# SUBMISSION TO AN BORD PLEANÁLA

## OBJECTION TO PROPOSED STRATEGIC INFRASTRUCTURE DEVELOPMENT

**Case Reference:** PA07.324113

**Proposed Development:** Cashla Peaker Plant (334 MW Open Cycle Gas Turbine Power Station)

Drawing Title: **Turbine, Stack, Generator - Plan & Elevations**

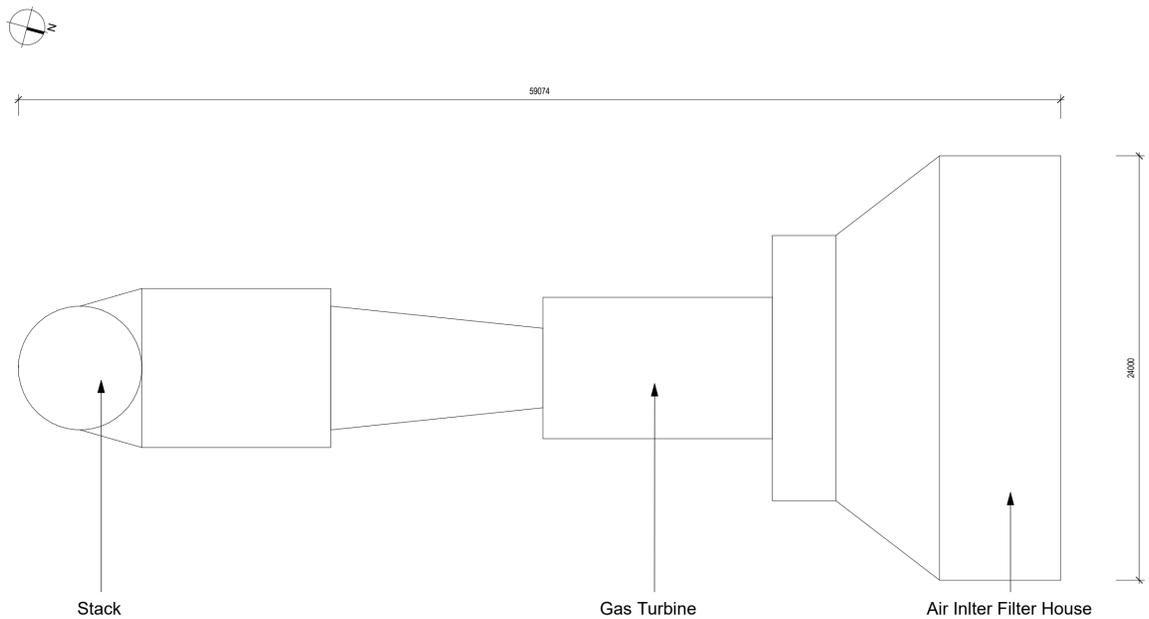
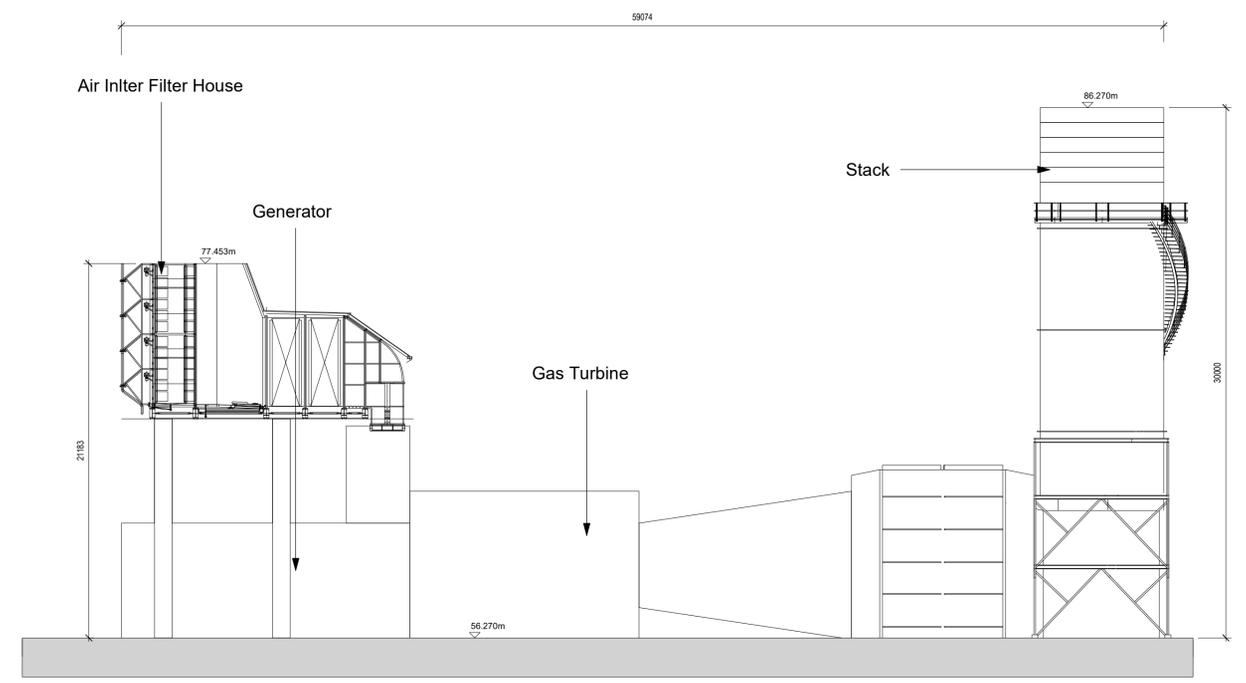
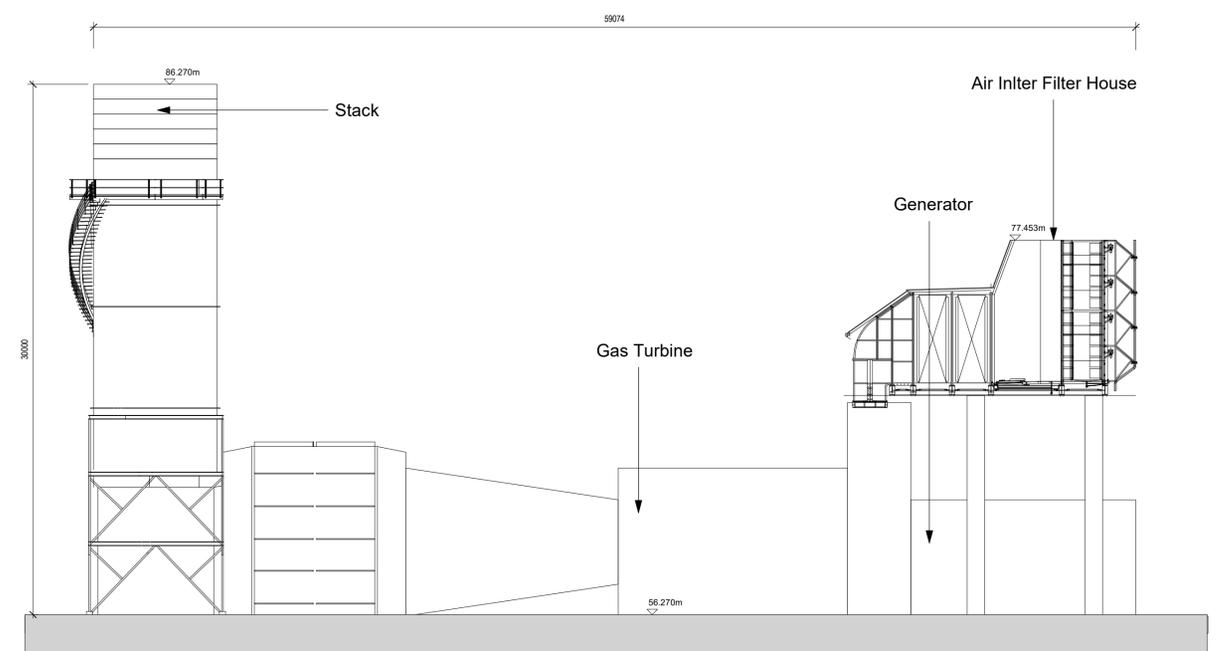
The proposed development includes chimney stacks of approximately 30 metres, industrial-scale buildings and infrastructure, and permanent night-time lighting—constituting a fundamental and irreversible change from rural to industrial character.

Purpose		PLANNING			
Title		SITE ACCESS SIGHTLINES			
Original Scale	Design/Drawn	Checked	Authorised		
SHOWN at A1	PS	ND	AJB		
Date	Date	Date	Date		
01.12.25	01.12.25	01.12.25	01.12.25		
Status	Drawing Number	Rev			
A2	PEK3-ATK-ZZ-01-DR-CE-901200	0

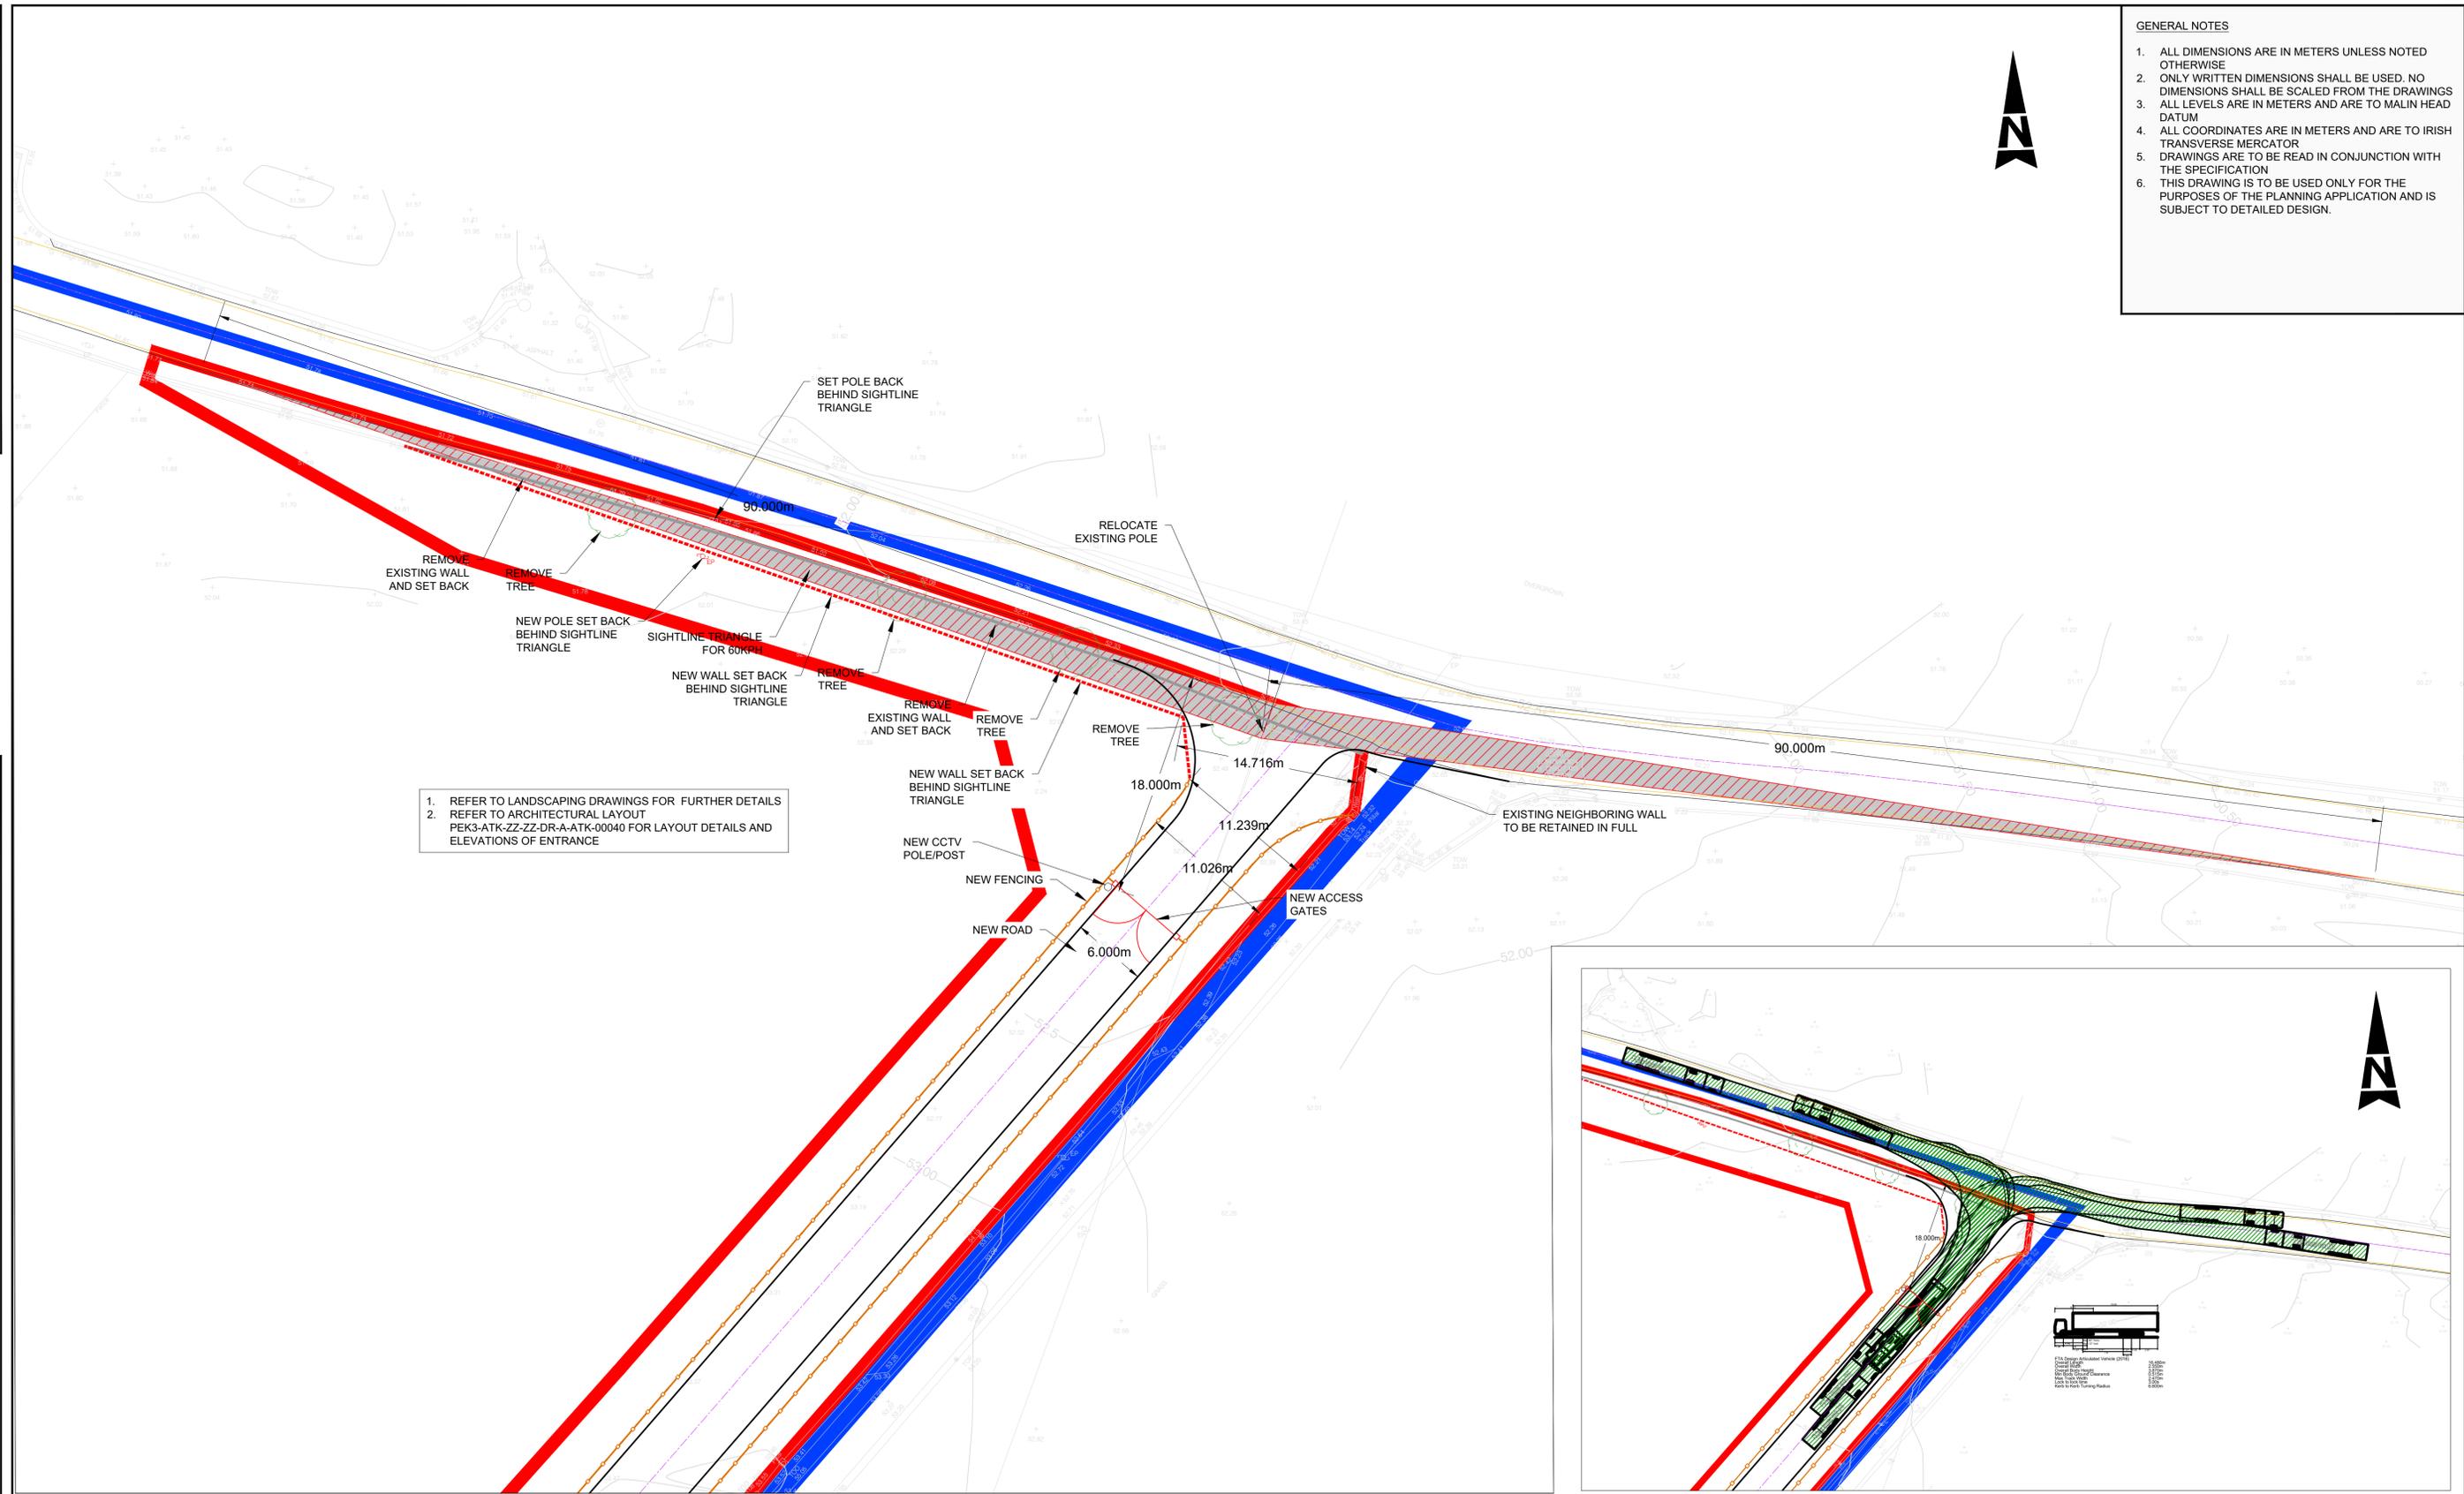
- the full grid connection route;
- public road verges; and
- a private road owned by residents, which the applicant appears to rely upon for access.
- No consent has been provided for use of this private road. Our understanding is that all residents must agree outside of agricultural use and it would appear that the applicant is bringing heavy machinery on our private road. See Map of the road in question attached. road attached.

- all EIAR deficiencies identified;
- full legal documentation confirming land and access rights; and
- explicit exclusion of any private road unless lawful consent is provided.
